DECISION DELEGATED TO HEAD OF PLANNING

Application No: H08-0904-24 **Applicant:** Mr & Mrs T Waltham

Proposal: Details of schedule of materials for hard surface areas, scheme to deal with contamination, storage & disposal of refuse & recycling, foul & surface water disposal, scheme of construction management, boundary treatments & landscaping & tree planting (Conditions 4, 6, 7, 9, 10, 11 & 13 of H08-0861-23)

Location: Land Between 10 & 12 Risegate Road Gosberton Risegate Spalding

DRAWING: SITE LAYOUT PLAN
CONSTRUCTION MANAGEMENT PLAN

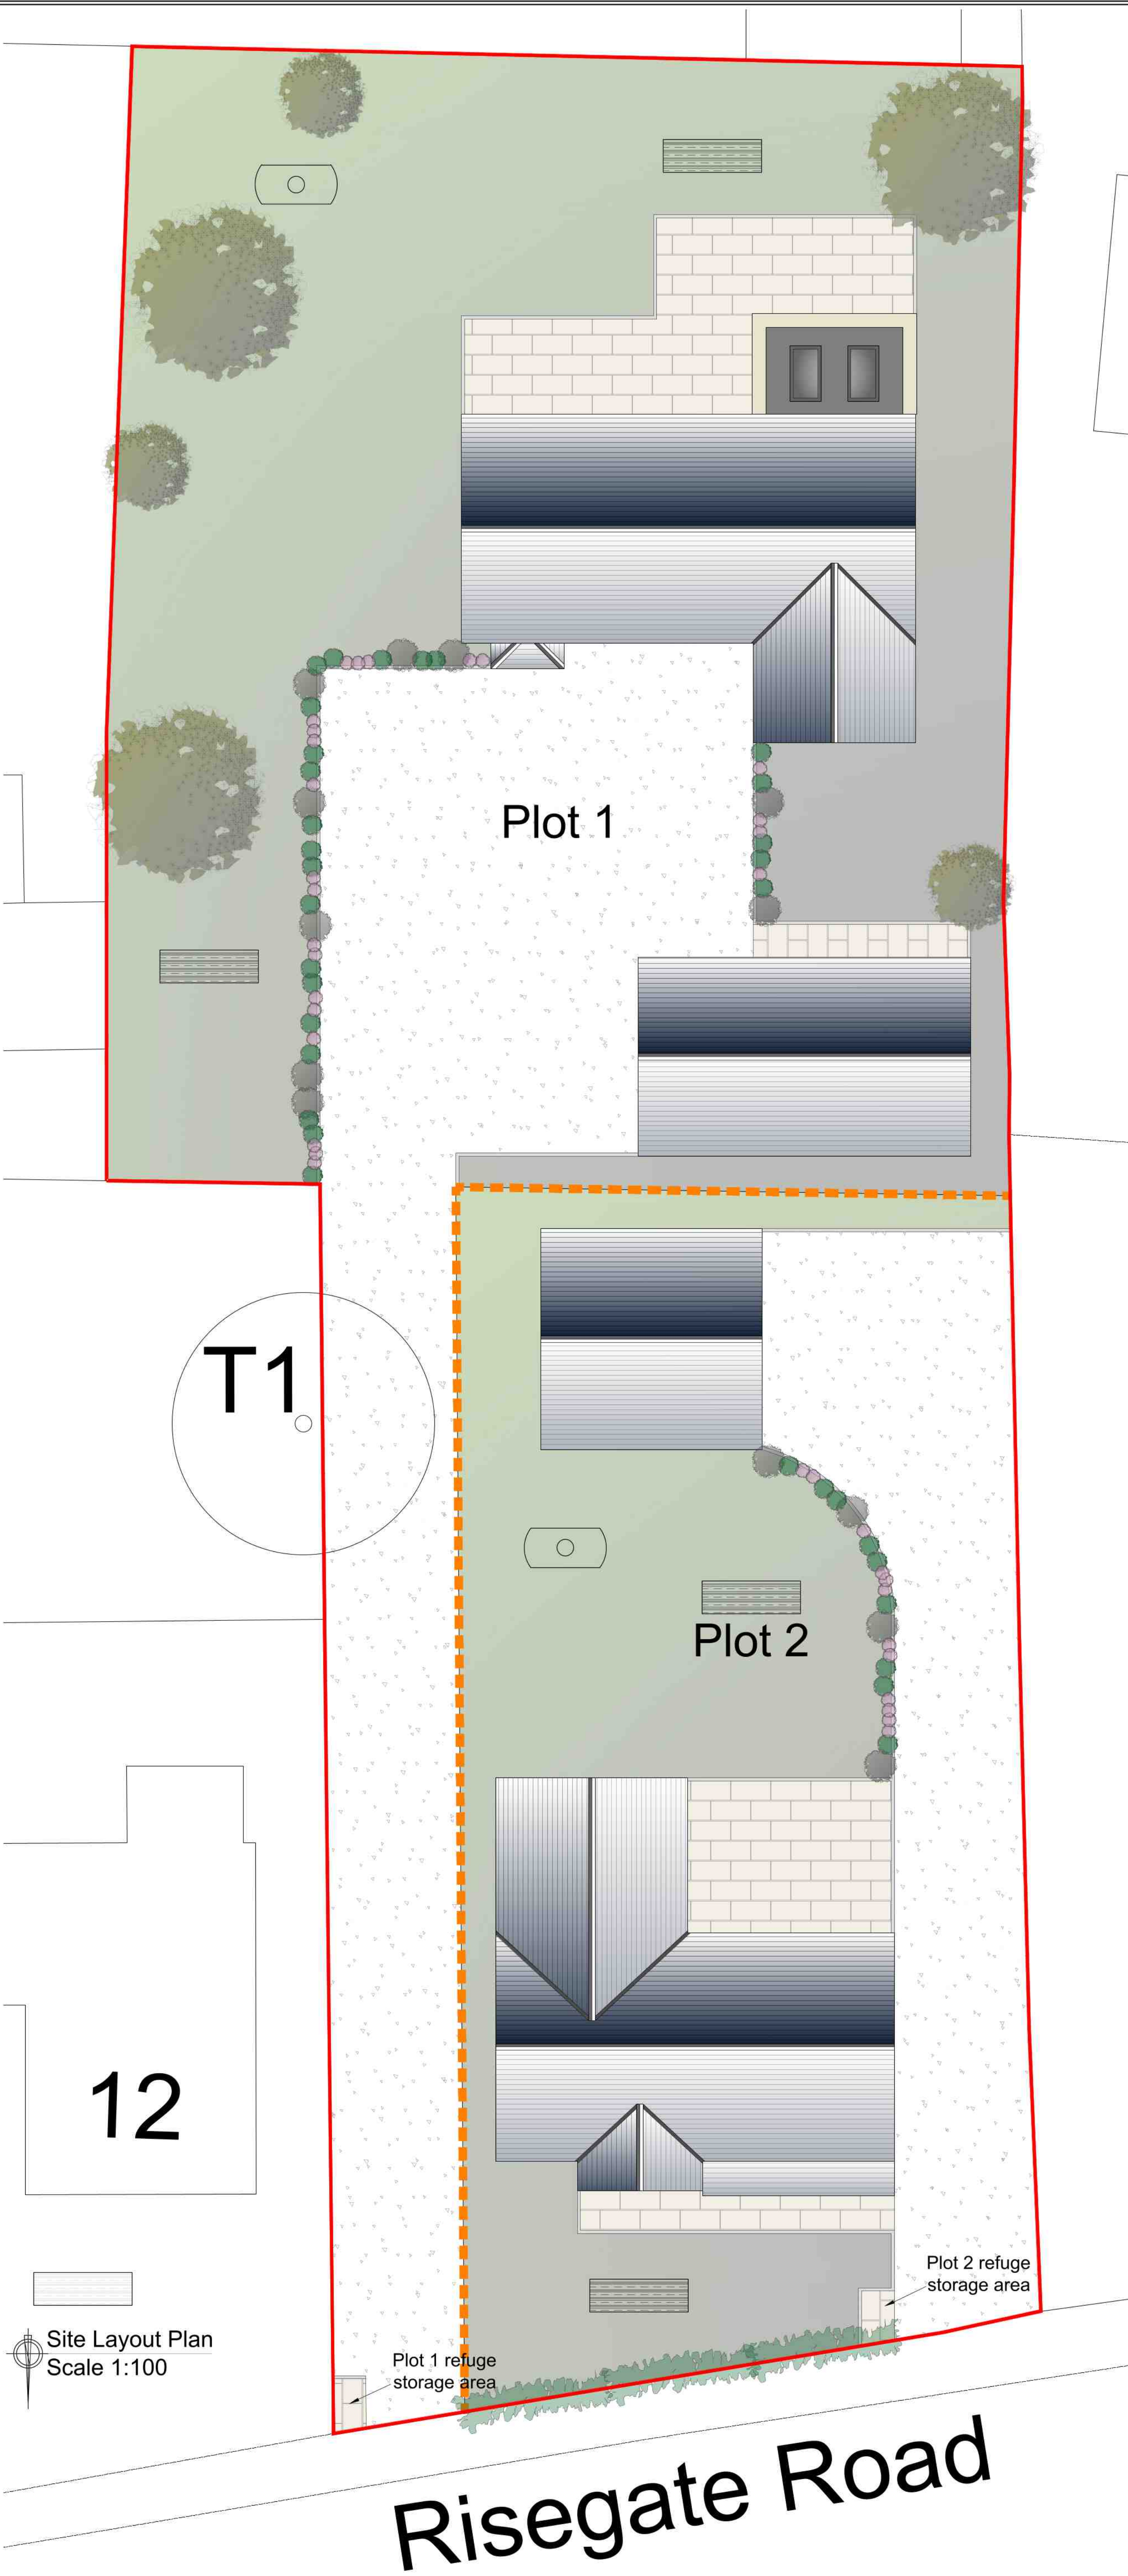
"ADDITIONAL INFORMATION REQUIRED Condition 11 - In terms of the front boundary treatment at the highway boundary - this shall not exceed 0.6m in height"

Both dwellings would have a rear patio area, constructed of porcelain paving slabs. The driveways

and turning points would be gravelled, using golden gravel, to a depth of between 20 and 50mm, laid over 150mm of class 1 hardcore. This would be laid on a geotextile membrane.

The submission shows two refuse collection areas, one for each dwelling, located adjacent to the site access point. The refuse collection point for Plot 1 is located approximately 50 metres from the dwellinghouse. This does contravene the 30 metre carry distance outlined within the aforementioned guidance note. However, said note is strictly guidance, and therefore, the weight attributed to this is limited. Only one dwelling would be affected by this increased carry distance and not to such an extent as to be detrimental to residential amenity.

With respect to surface water disposal, the supporting statement outlines that water will discharge via soakaways, in the form of soakaway crates. These shall be located in the front and rear garden of each plot. These are considered to be appropriately positioned given the scale of the development.

Turning to foul water, within the supported document it is stated that the waste would be disposed of by a treatment plant, then treated water distributed via suitably designed soakaways. The treatment plants will be located within the rear garden of each plot. This is considered to be an appropriate strategy given the constraints of the site.

The submitted construction management plan, while relatively limited in detail, appears acceptable given the scale of the proposed works. The details provided appear to secure the necessary protection for nearby residents and for the protection tree adjacent to the site.

The submitted landscape plan details a 2.1 metre high close boarded fence would be installed along the east and west boundaries, as well as at the boundary between plots 1 and 2. Along the southern boundary would be a 1.2 metre high close boarded fence.

The highway authority have also raised concerns regarding the height of the proposed frontage boundary treatments, citing visibility concerns. However, as this is a hedge, and could reasonably grow out without the need for planning permission, it would be inappropriate to resist the application on this basis.

The submitted landscape plan shows a 1.8 metre high native hedge along the southern boundary. Sporadic, low-level planting is proposed throughout the site.

Given the constraints of the site, including the protected tree, the proposed schedule of hard surfacing is considered appropriate.

As such, it is considered that Condition 7 has been satisfied.

As such, it is considered that Condition 9 can be discharged.

As such, it is considered that sufficient details have been submitted to discharge Condition 11.

While no metric has been submitted, it is clear that net gain has been achieved on site. As such, it is recommended the condition be discharged.
